WEST SUSSEX COUNTY COUNCIL CONSULTATION

TO:	Arun District Council FAO: Michael Eastham
FROM:	WSSC - Public Rights of Way
DATE:	31 March 2021
LOCATION:	Land South of Ford Lane east of North End Road Yapton Arundel BN18 0DS
SUBJECT:	Y/131/20/DOC Approval of details reserved by condition imposed under ref APP/C3810/W/17/3170059 (Y/80/16/OUT) relating to Condition Nos 7 - means of access/egress onto Ford Lane, 8 - retention & improvement of Public Rights of Way 357, 358, 359 & new cycle & pedestrian routes, 9 - Stage 1 Road Safety Audit, 12 - Travel Plan and 17 - Phase 1 Habitat Survey. Submitted plans received. More information received from Michael Eastham's email on 24th March.
DATE OF SITE VISIT:	n/a
RELEVANT PUBLIC RIGHTS OF WAY NUMBER(S):	FP357/FP358
RECOMMENDATION:	Advice / No Objection
S106 CONTRIBUTION TOTAL:	n/a

Drawing Title
Sections through public right of way footpath 357

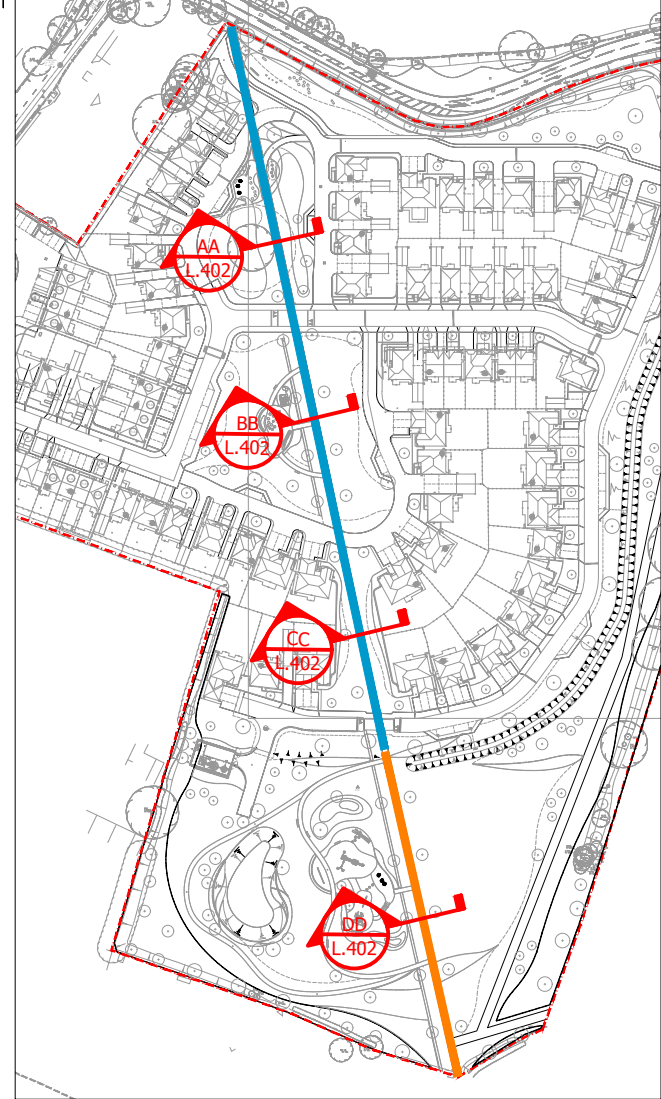
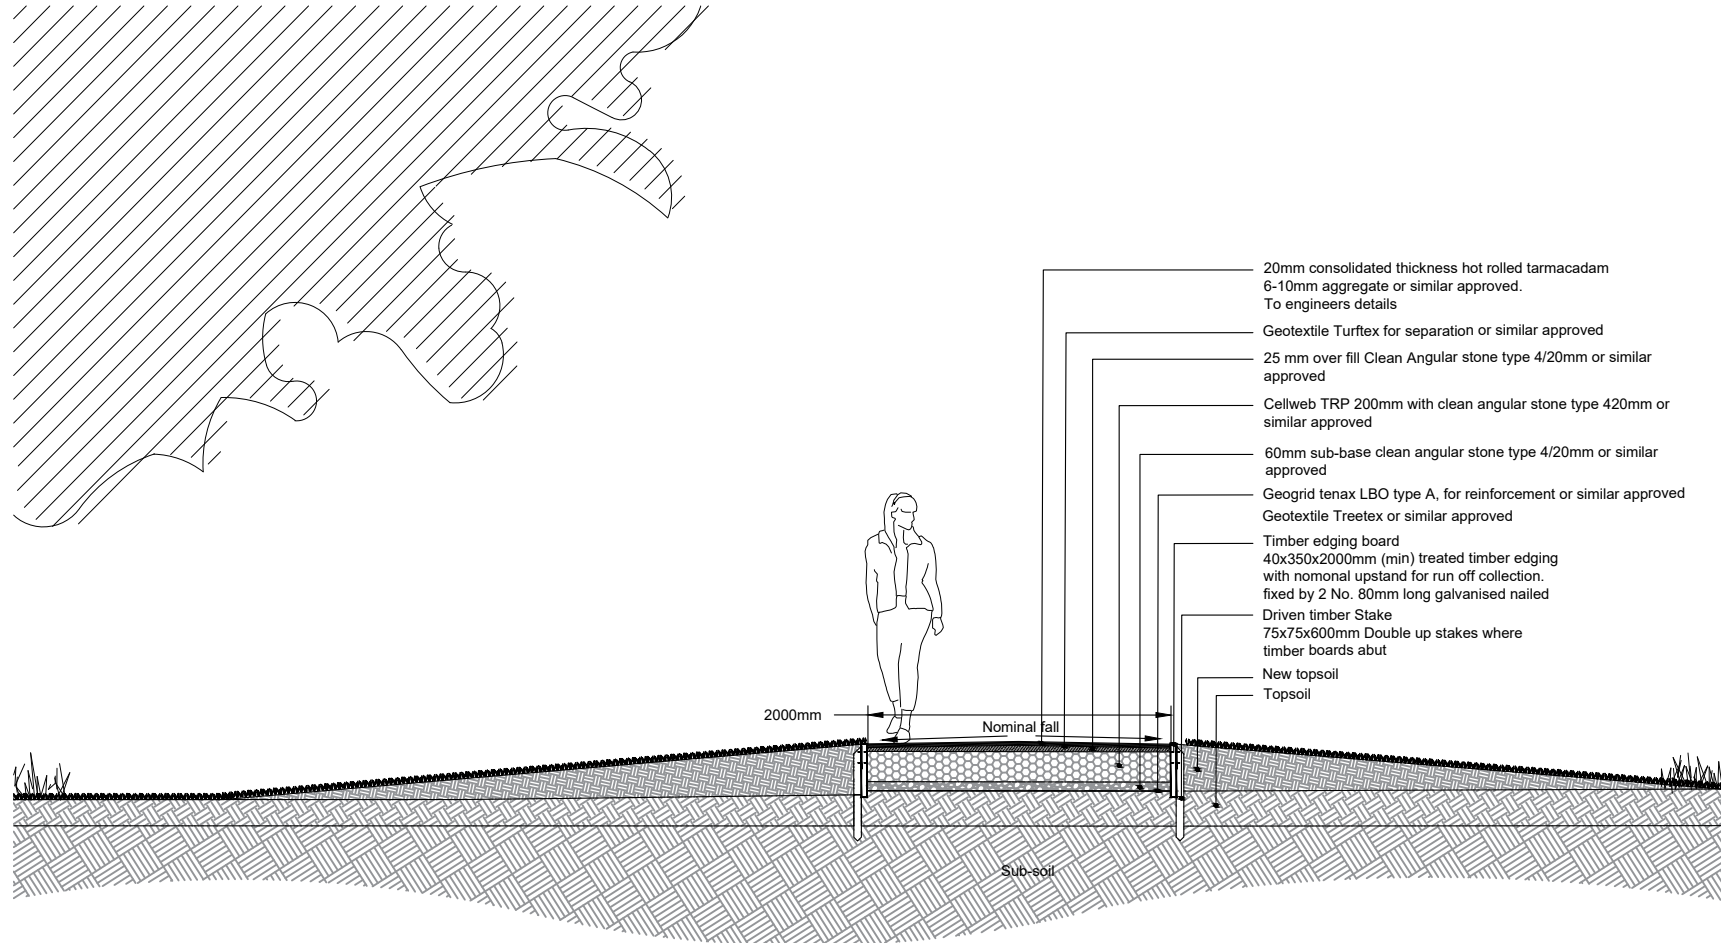
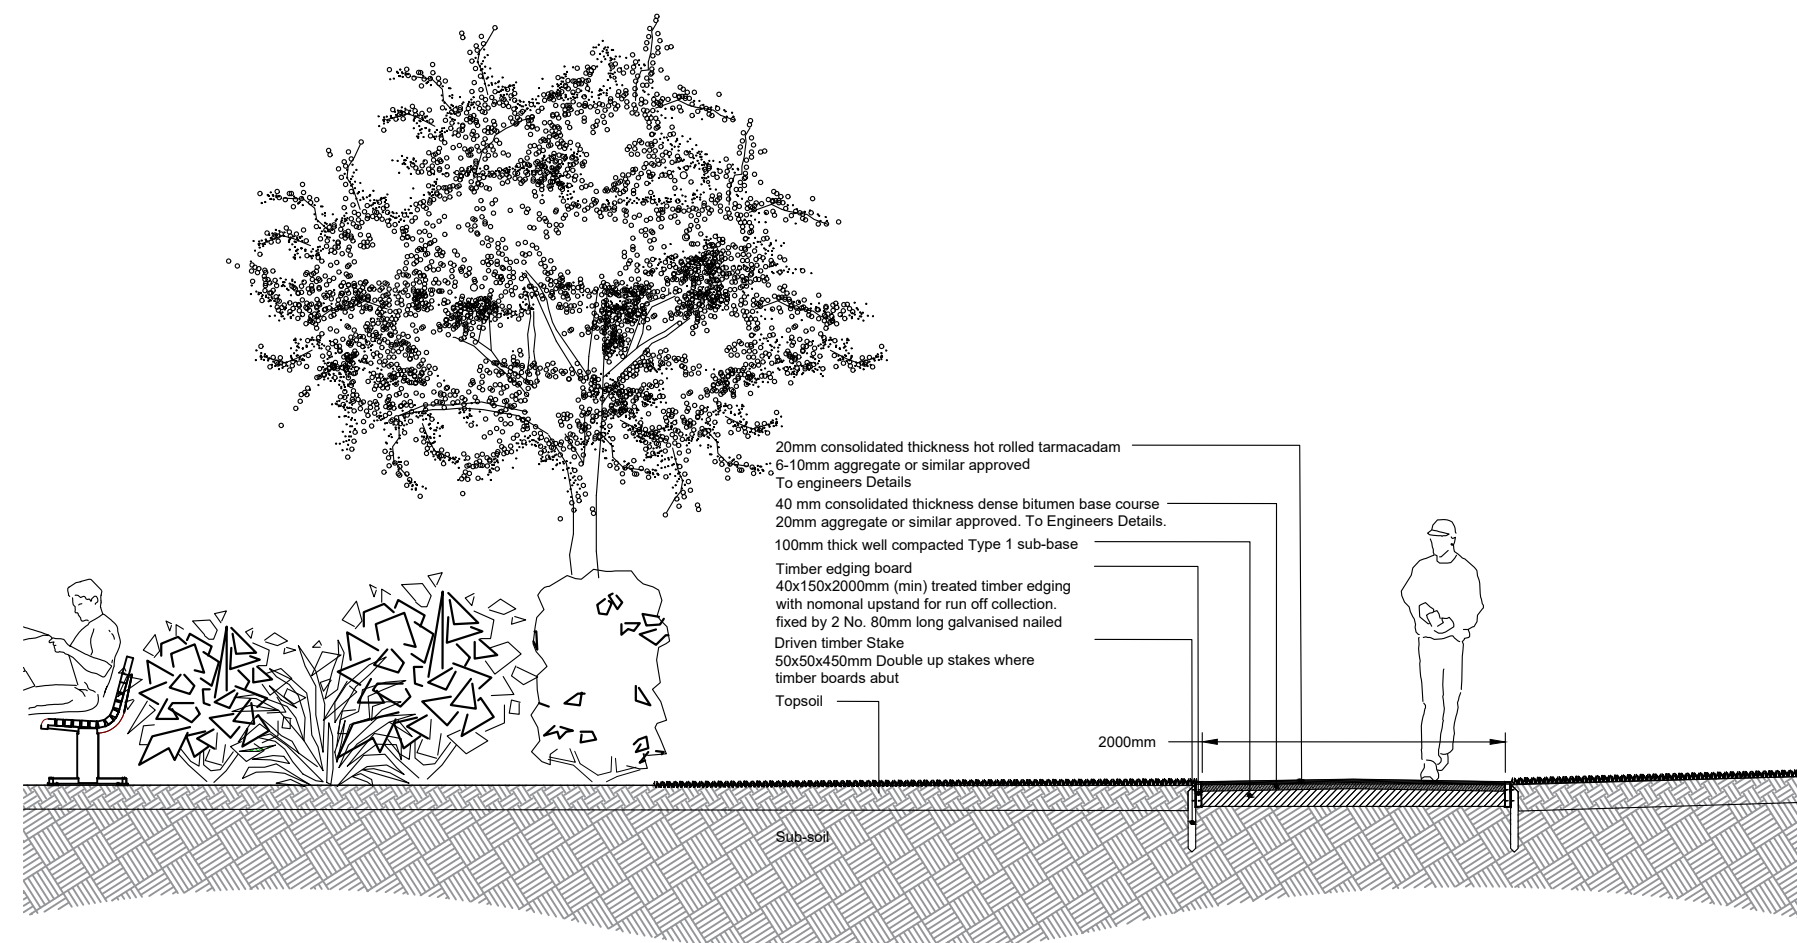
1. Problem B.2.1 – It is my understanding that the steps currently providing pedestrian access to Ford Lane at the northern end of Public Footpath 357 and referred to in the Safety Audit are to be removed and replaced by a ramp as part of the S278 works for Ford Lane. Please would you check this and if correct, refer to the Audit Team for any further comments. Following that, you will need to re-visit the Designer's Response in-light of the ramp (if confirmed) and any comments forthcoming from the Audit Team.
